# LADACAN response to Rule 17 letter 31 Jan 2024 IP ref 20040757

This is LADACAN’s response to the ExA’s question regarding **Noise insulation delivery programme** copied below from p2 of the Rule 17 letter dated 31 January 2024:

Since the R17 letter was issued, the “Draft Compensation Policies, Measures and Community First” document has been substantially revised and so LADACAN is commenting on REP9-032 rather than REP7-036 in respect of the Noise insulation delivery programme (“the Programme”).

**APPENDIX A – INDICATIVE NOISE CONTOUR PLANS**

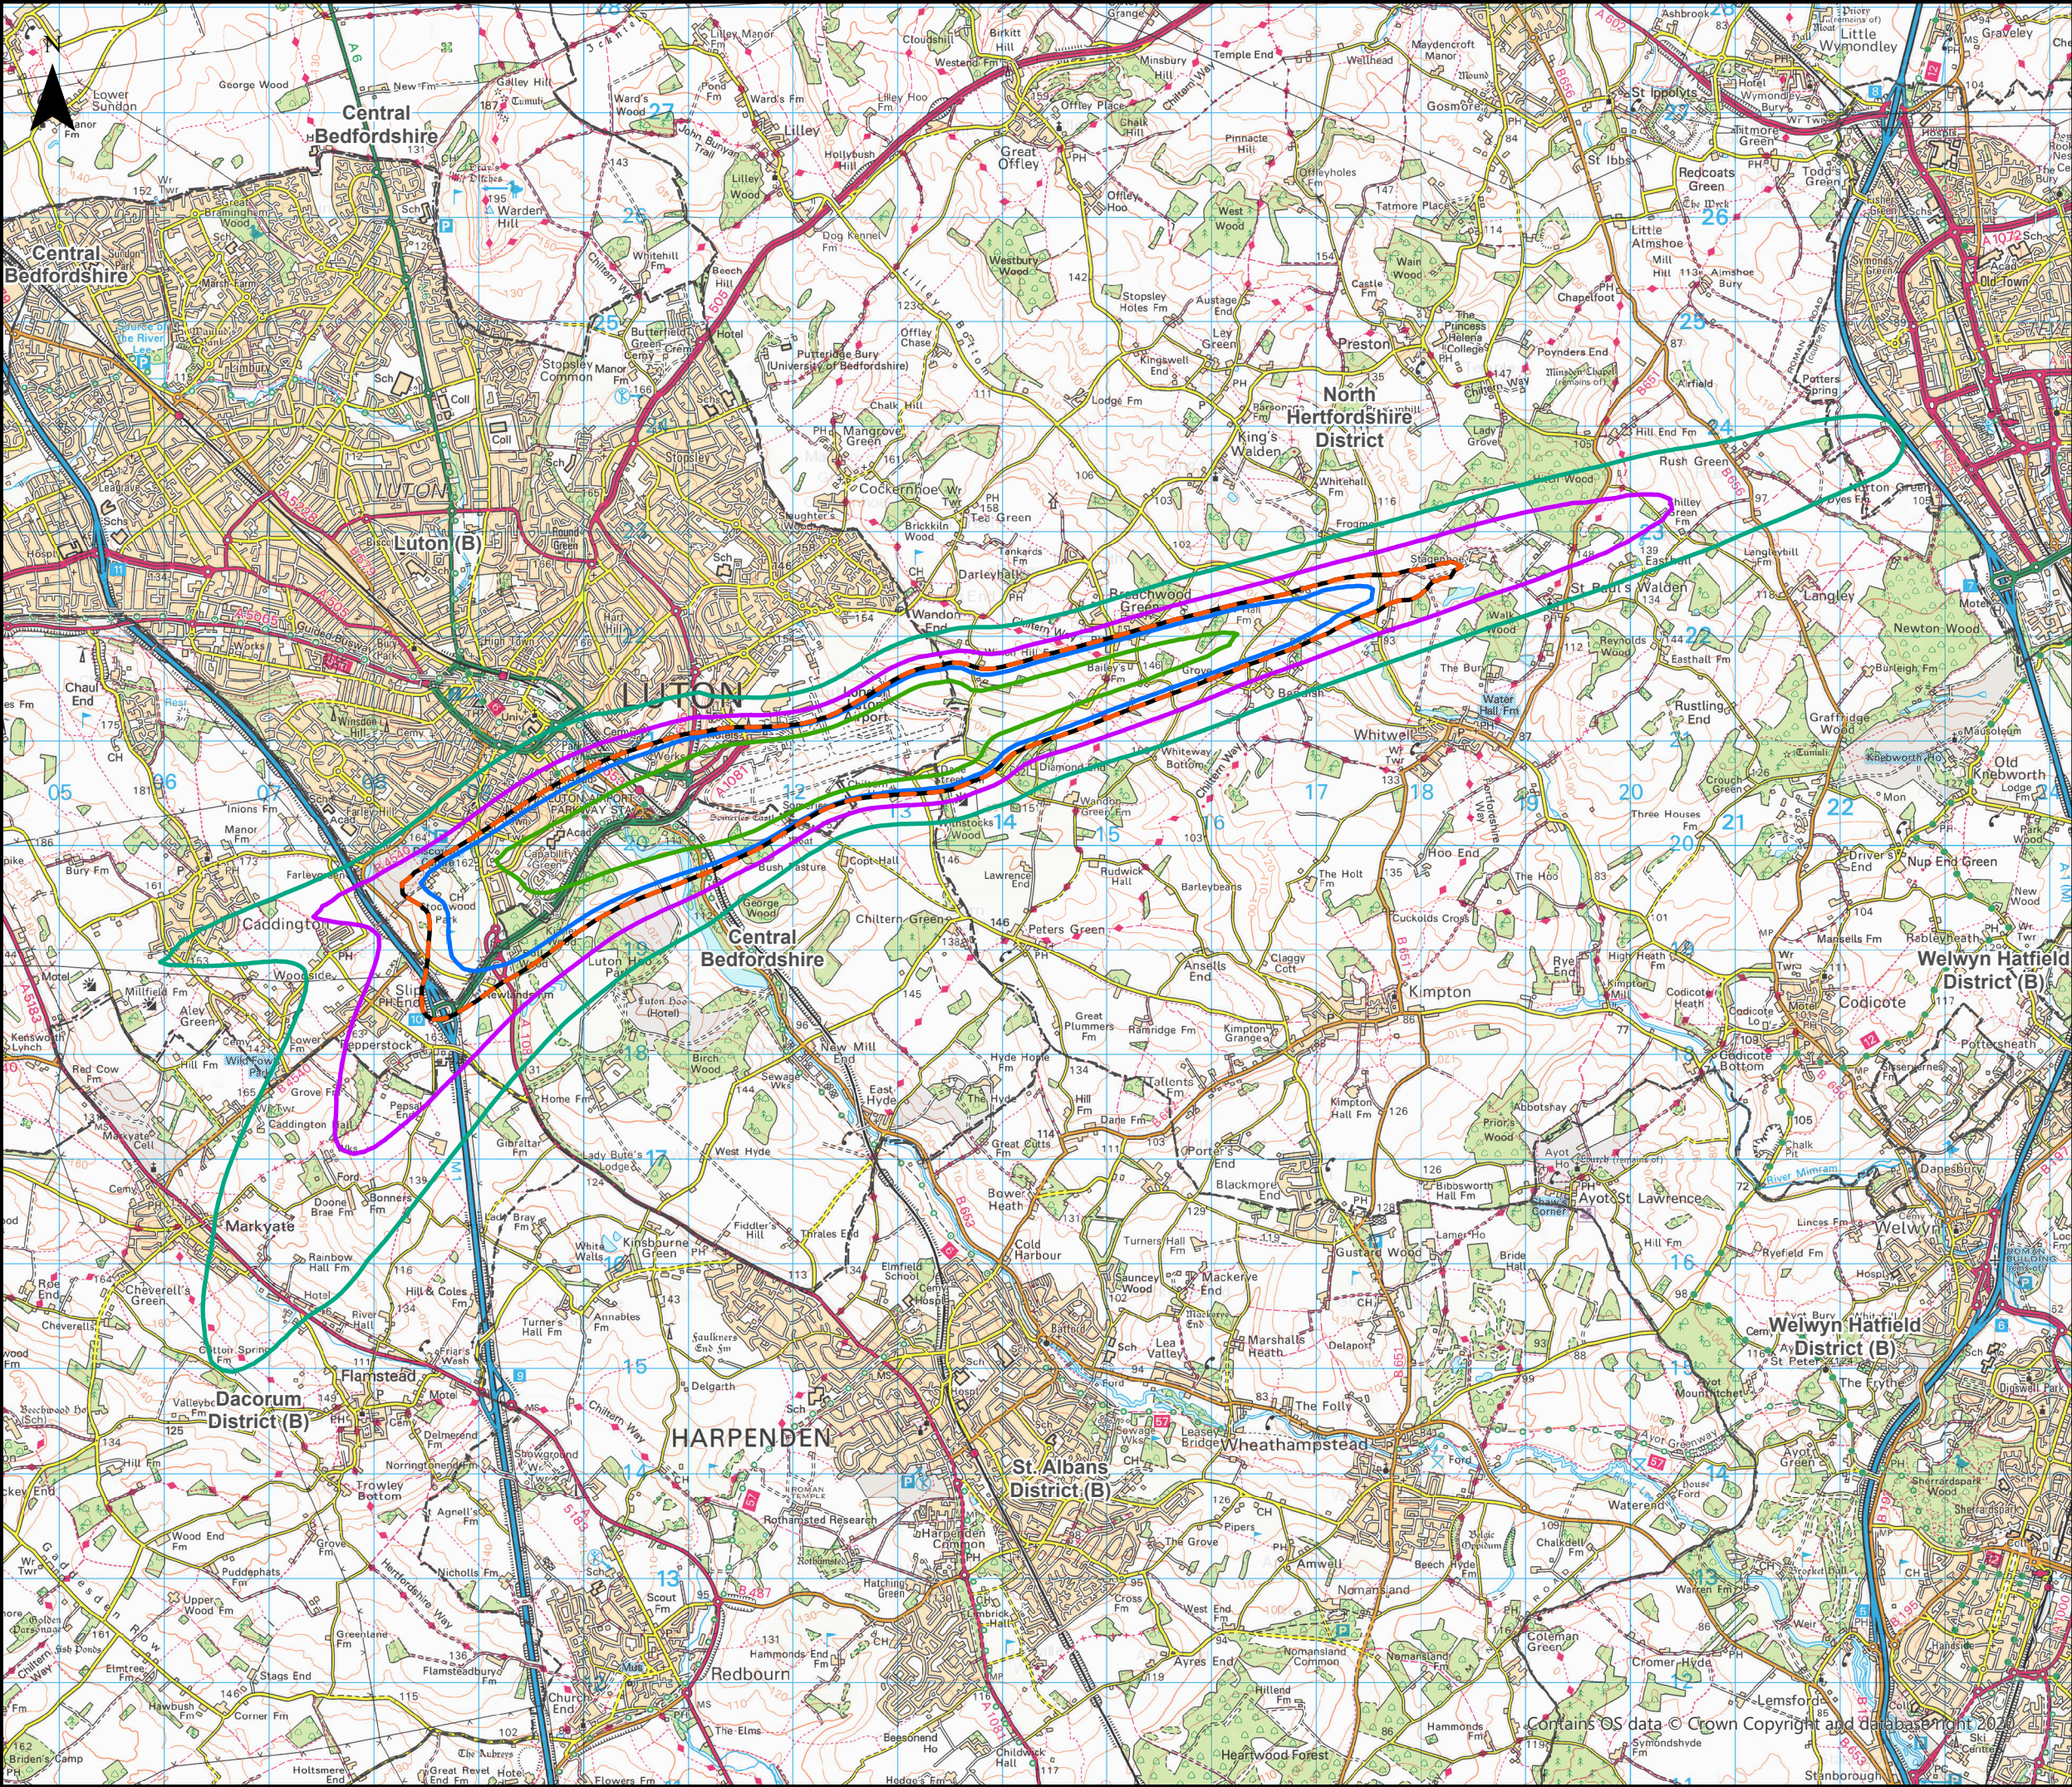
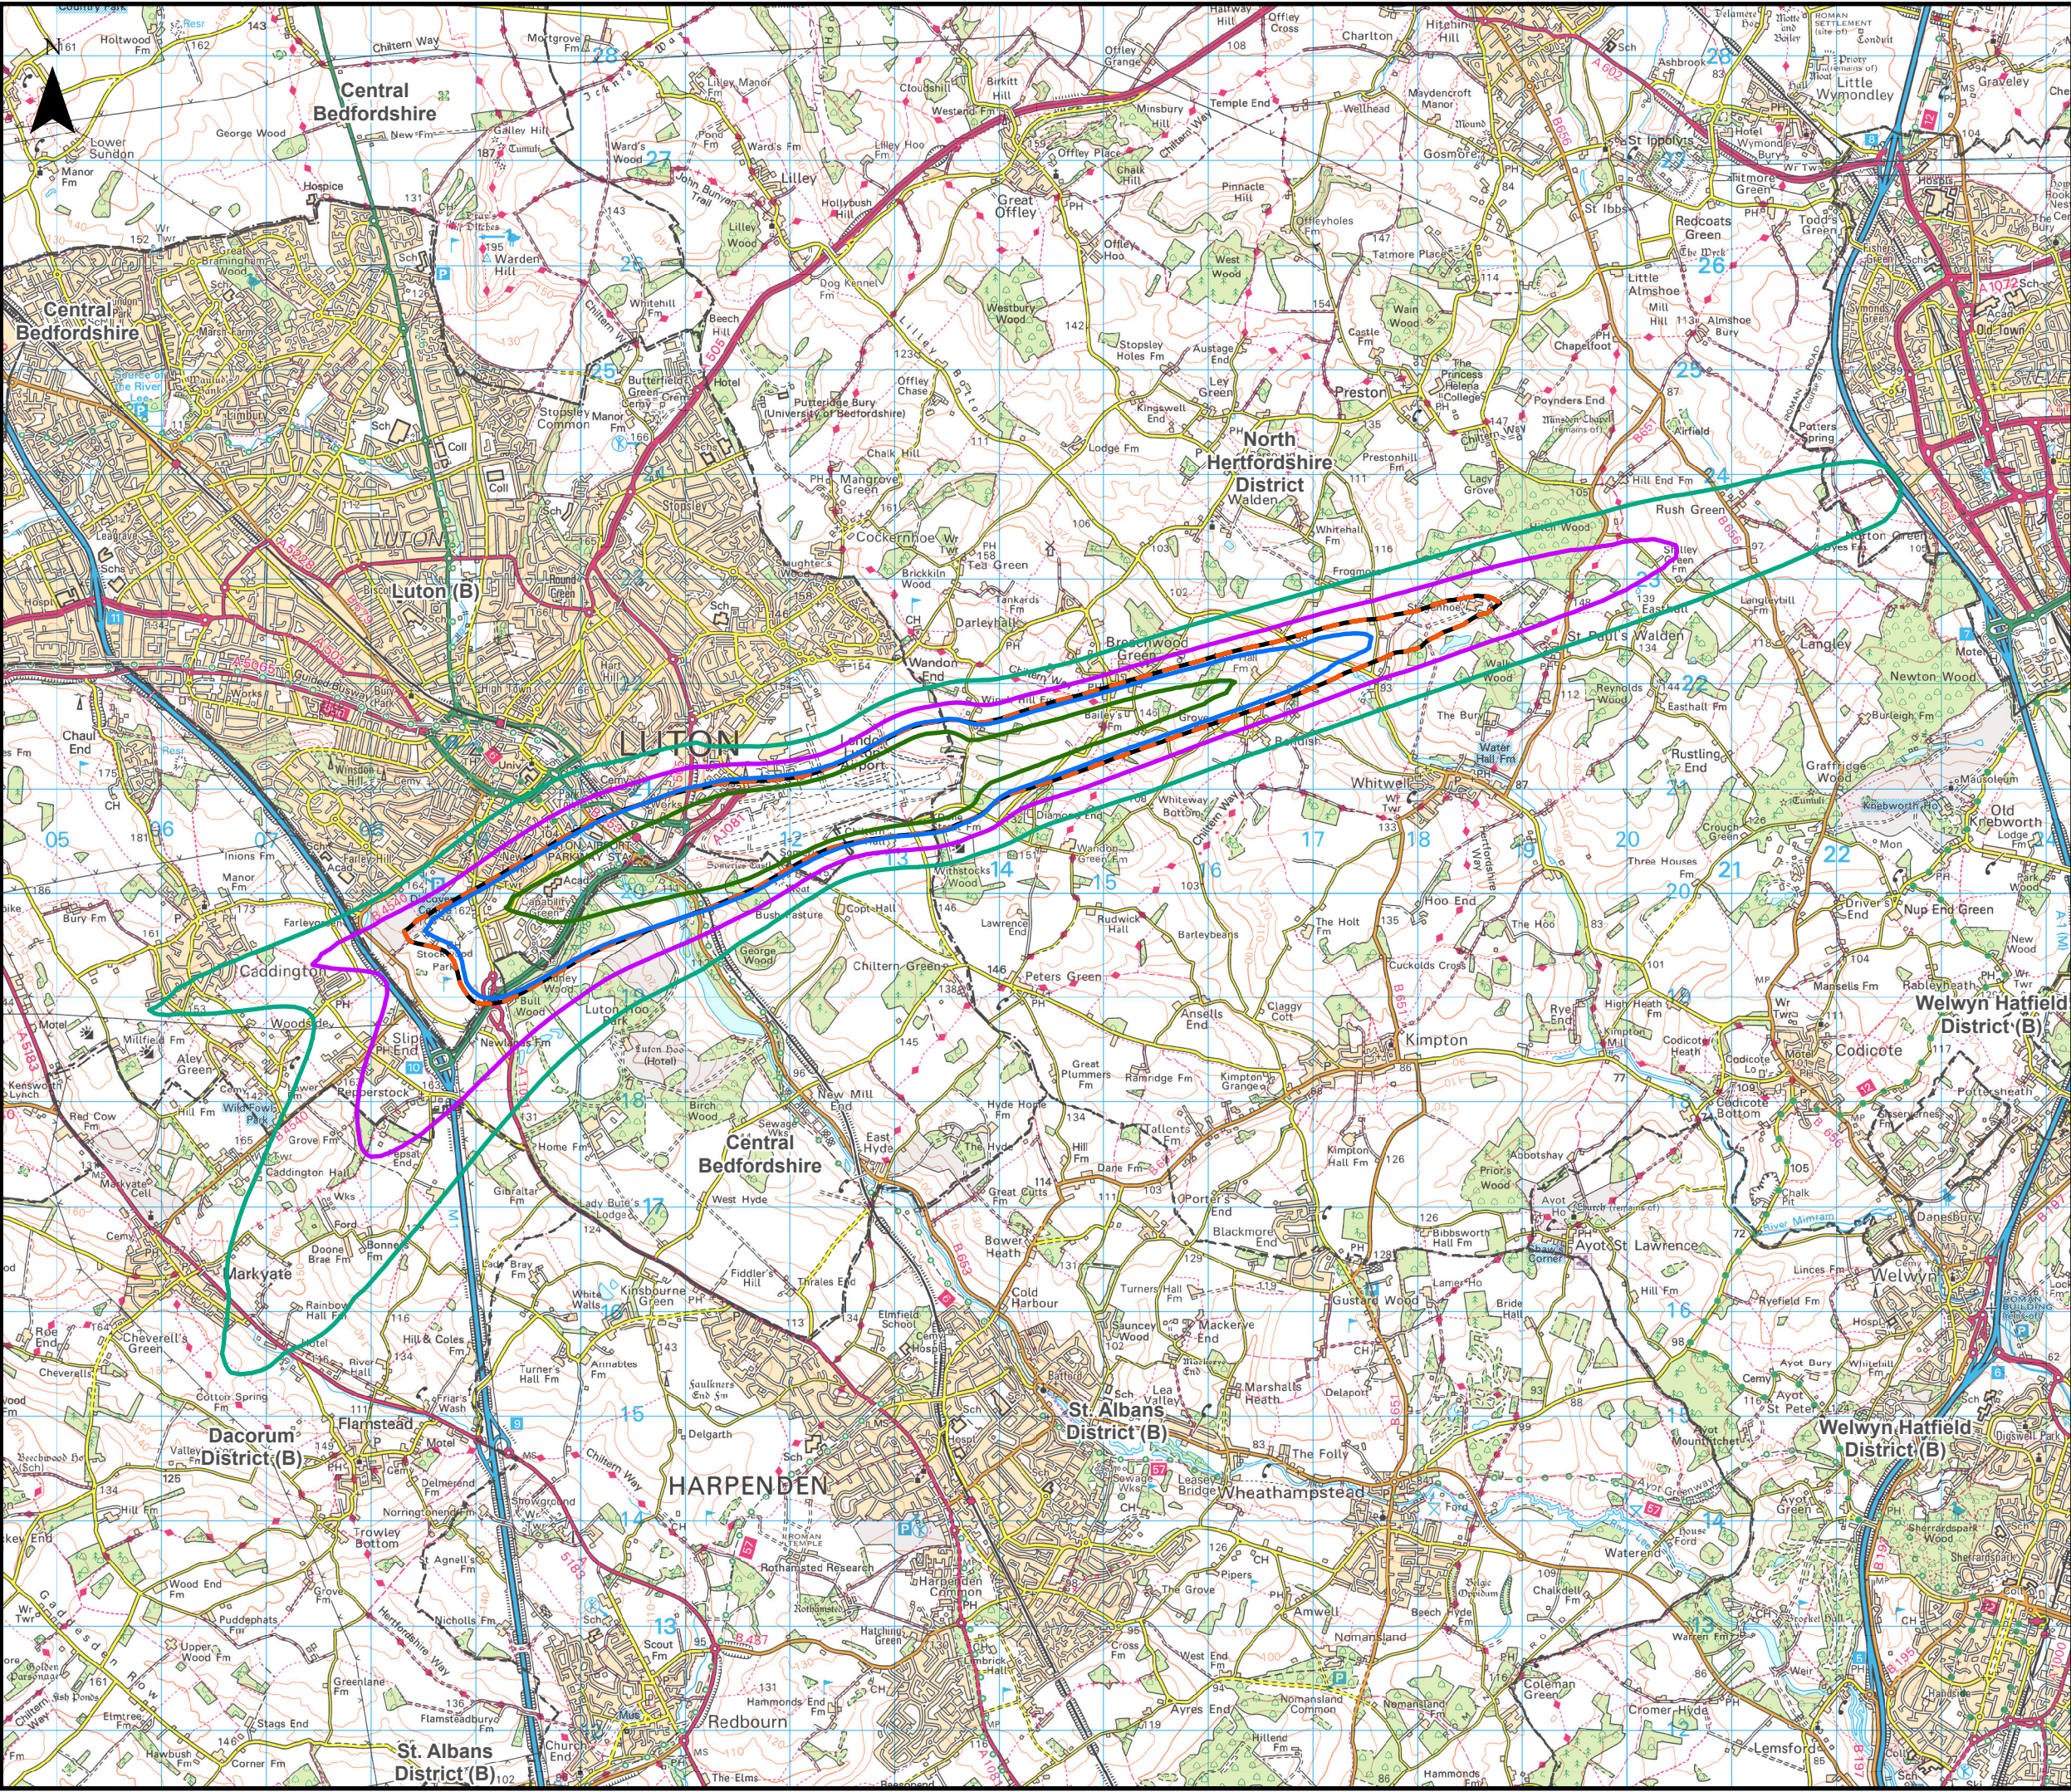
which omits the “outside the 60dB day contour” requirement, as does the wording in the key to the contour maps on PDF pages 36, 38, 40, 44 and 48 which define Scheme 3 as:

*“Scheme 3 - 55dB LAeq,8h Night-Time Contour”*

It is clear from the contour maps which show both the 55 dB LAeq,8h night-time contour and the 60dBLAeq daytime contour that the outlines are nearly identical, with the northern edge of the blue (60dB) line in fact falling outside the dashed blue-orange (55dB) line on its northern edge. Therefore, if the Scheme 3 specification is intended to apply only to properties “inside the 55dB night contour but outside the 60dB day contour”, it would be worthless. This should be corrected.
